Application Ref:	3/2025/0282			 Ribble Valley Borough Council www.ribblevalley.gov.uk
Date Inspected:	01/05/25	Site Notice:	N/A	
Officer:	LW			
DELEGATED ITEM FILE REPORT:				APPROVAL

Development Description:	Proposed redevelopment of the existing dwellinghouse, including first floor extension, raising of the roof pitch, installation of rooflights and new roof to existing garage. Demolition of existing rear conservatory and construction of single storey rear extension and new front porch. Addition of new render and composite boarding to external elevations.
Site Address/Location:	11 Whittam Crescent, Whalley, BB7 9SD.

PROPOSED STREET SCENE

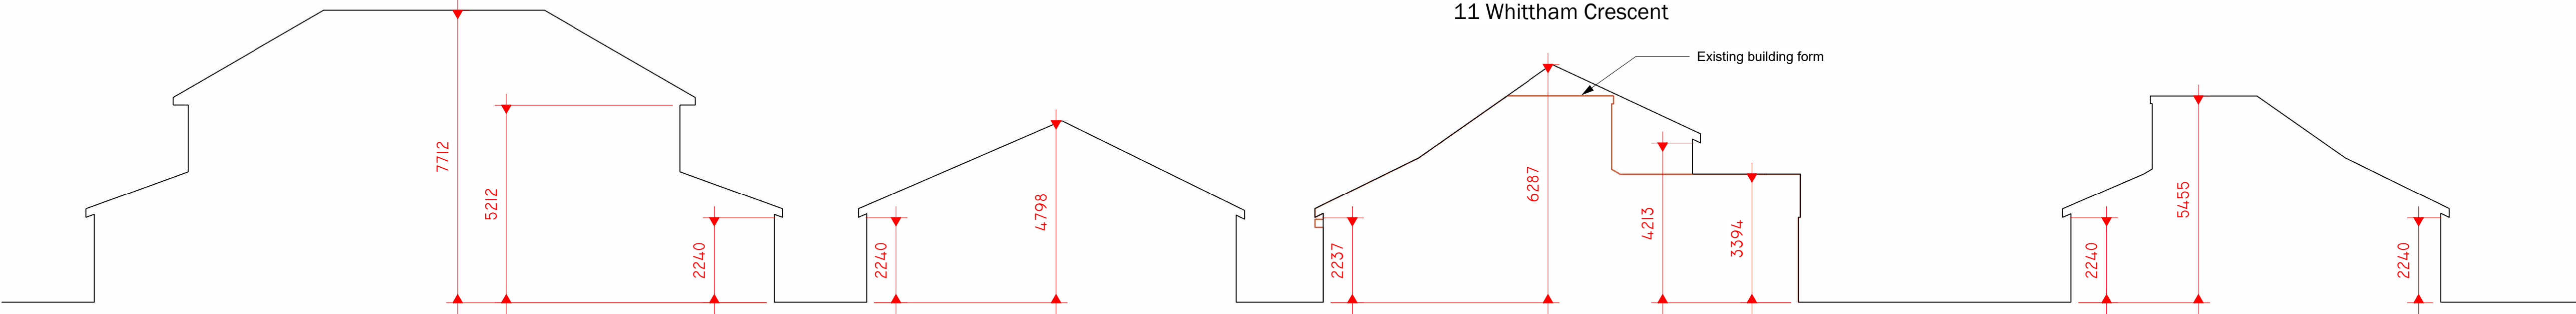
The proposed ridge raise would increase the height of the dwellinghouse by approximately 0.8m which is not considered to result in any significant adverse harm when read in context with the existing residential properties along Whittam Crescent. It is also not considered, on balance, that the proposed first floor

extension would appear so incongruous or discordant so as to justify a refusal to grant planning permission.

The proposed porch has been amended since initial submission, with the original scheme proposing a mono-pitch roof form with an eaves and ridge height of approximately 2.5m and 4m respectively. This was considered to result in an unsympathetic addition to the application property and as such, a dual pitched roof design is now proposed measuring approximately 2.5m to the eaves and 3m to the ridge. The amended design of the porch is considered to sufficiently address the aforementioned concerns, with the proposed addition now considered acceptable. The proposed incorporation of a lean-to roof to the existing flat roof integral garage is also considered acceptable in this particular instance, given numerous other properties within the immediate vicinity of the proposal site benefit from a similar addition, namely nos. 13 and 15 Whittam Crescent.

PROPOSED SITE PLAN AT 1:200

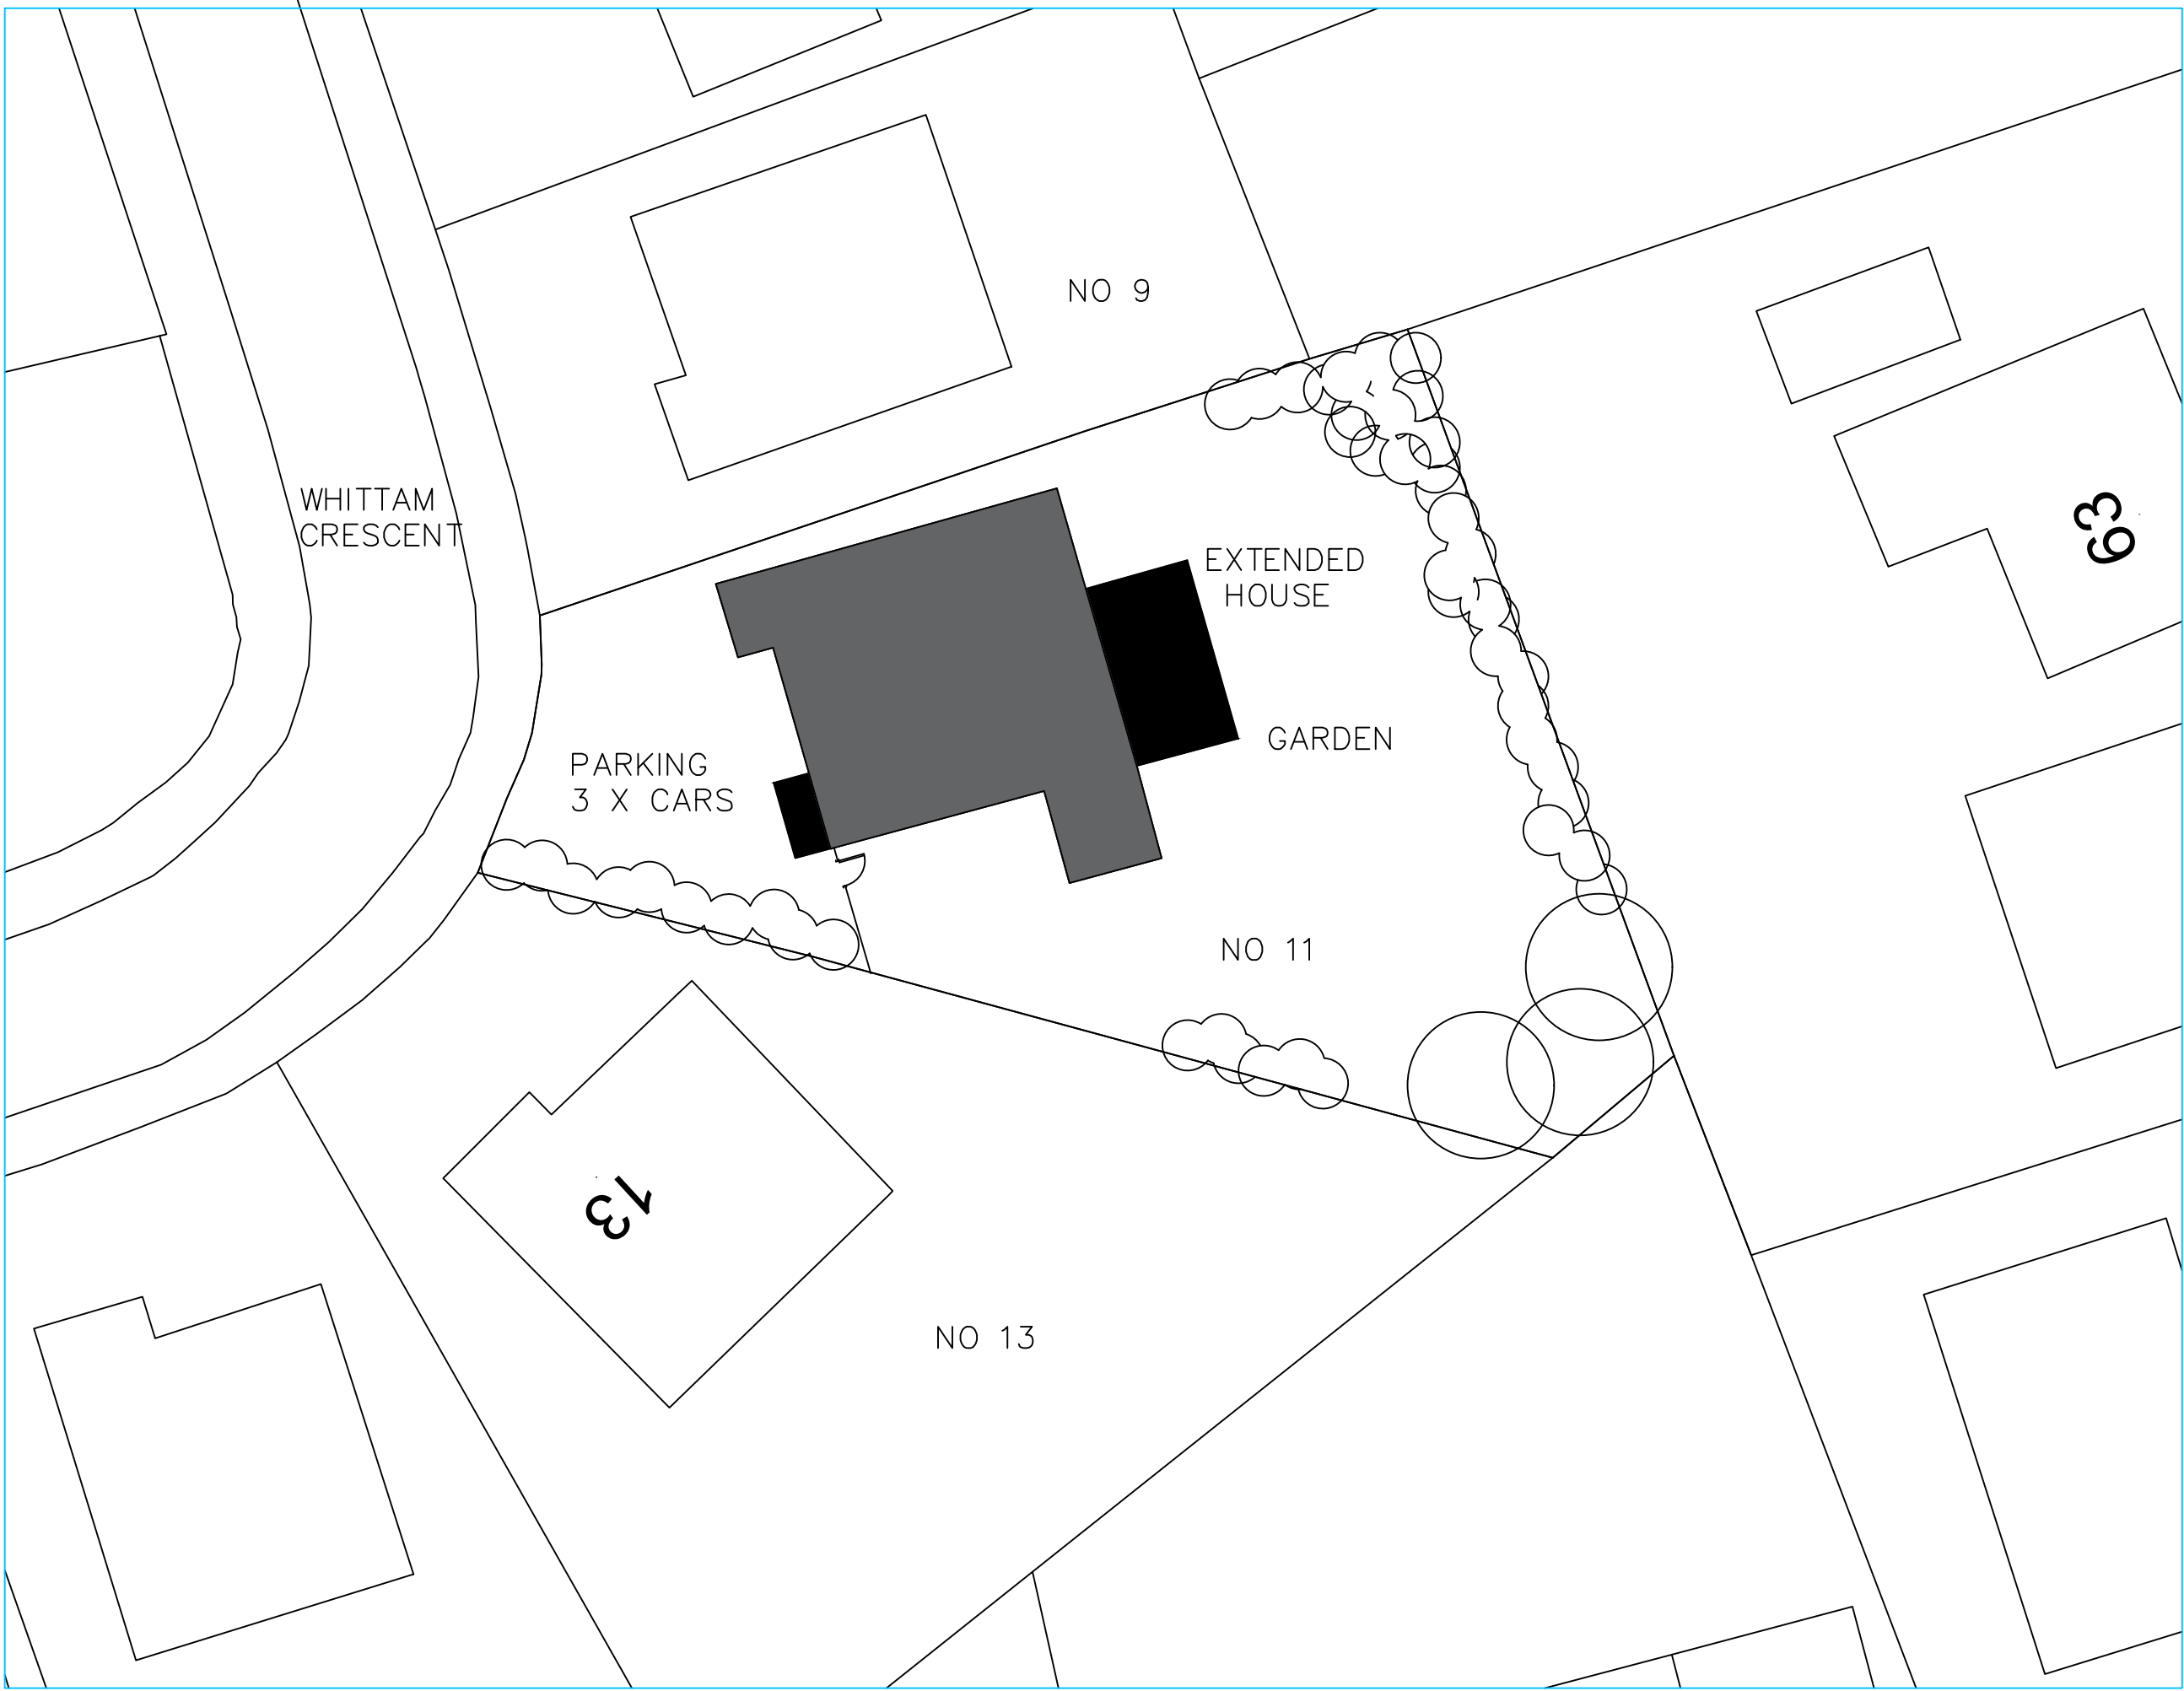
Lancashire County Council Highways have been consulted on the proposed development and raised no objection. Three parking spaces could be accommodated on the driveway to the front of the property which accords with parking standards.
